Ribble Valley Borough Council
Housing & Development Control

Application no: **3/2019/0436**

Address: **The Old Reservoir, Simonstone Road, Sabden, BB7 9HA**

Proposal: **Conversion of agricultural buildings to form holiday let**

plan

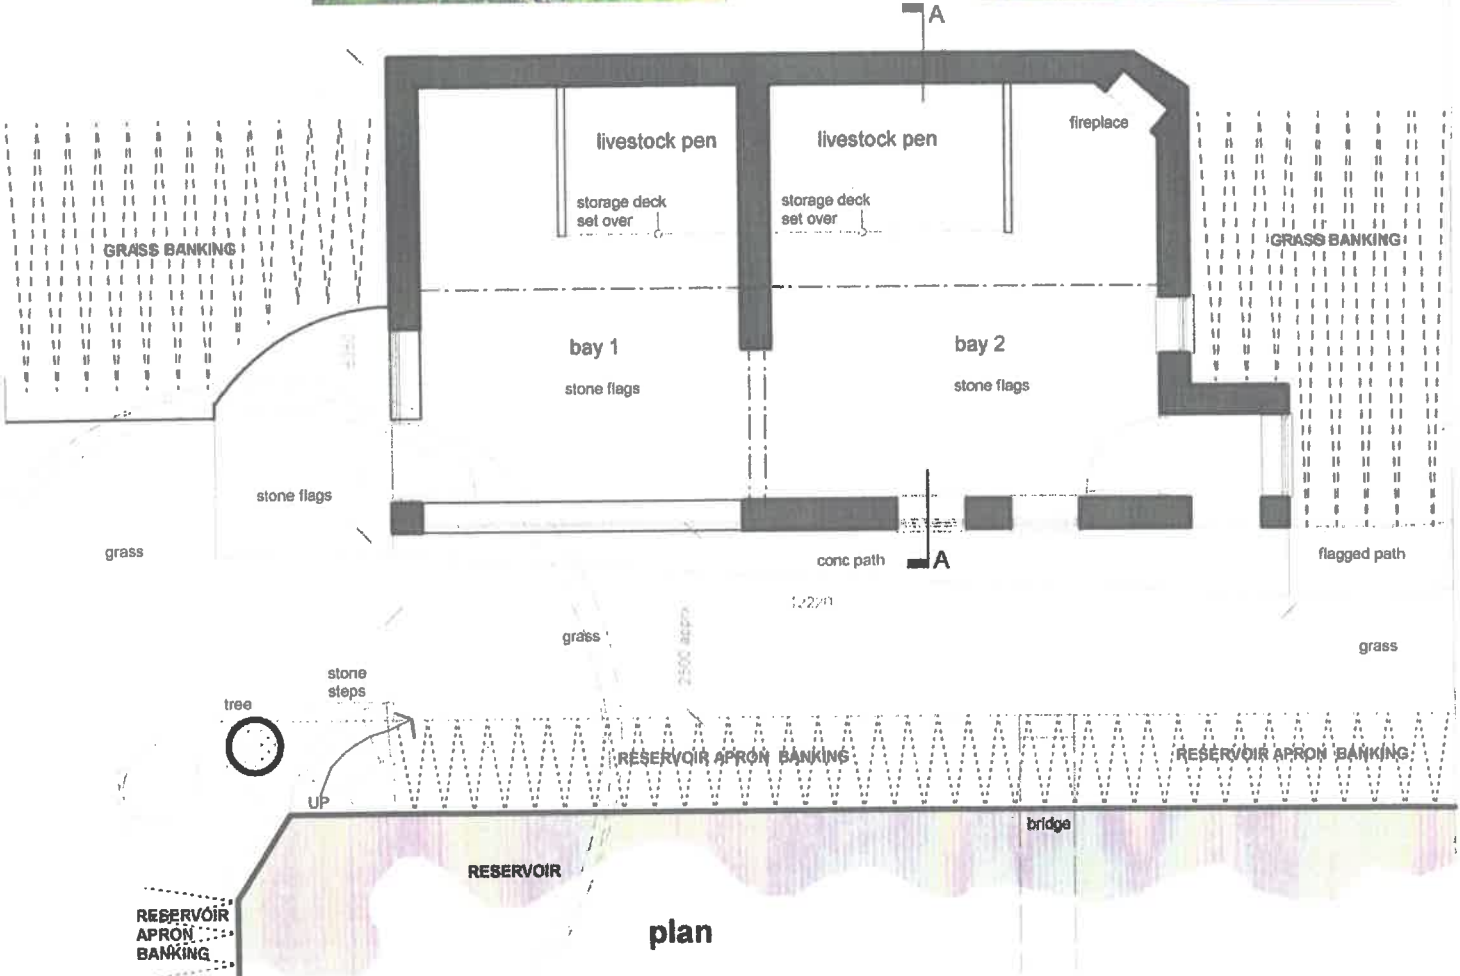
that the development proposal utilises an existing highway access and the scheme proposed offers a betterment in terms of access construction and visibility the proposal would be considered acceptable subject to the quoted visibility splays of 2 x 150m being achievable Northbound and 2 x 80m Southbound.

The visibility splays are to be maintained throughout perpetuity of the proposal and therefore the boundary wall fronting the application site must either be reduced to a height no greater than 1.05m or to be repositioned and set back behind the line of visibility, currently the boundary wall obstructs the visibility splay and in order to maximise visibility and achieve visibility splays of 2m x 150m Northbound x 80m Southbound, the concerns over the wall must be addressed. The overhang of the trees and vegetation to the south of the access point must also be maintained and permanently remain out of the visibility splays line of sight in order to achieve the readily available X and Y distances of 2m x 80m Southbound.

1. Notwithstanding the provisions of the Town and Country Planning (General Permitted Development) Order 1995 there shall not at any time in connection with the development hereby permitted be erected or planted or allowed to remain upon the land hereinafter defined any building, wall, fence, hedges, trees, shrubs or other devices over 1.05m above road level. The visibility splay to be the subject of this condition shall be that land in front of a line drawn from an X point measured 2m back into the site from Simonstone Road to Y points measured 150m Northbound x 80m Southbound along the nearer edge of the carriageway of Simonstone Road, from the centre line of the access are to remain clear of obstructions in perpetuity of the development. **Reason:** To ensure adequate visibility at the street junction or site access.

2. Before the access is used for vehicular purposes, that part of the access extending from the highway boundary for a minimum distance of 5m into the site shall be appropriately paved in tarmacadam, concrete, block pavements, or other approved materials. **Reason:** To prevent loose surface material from
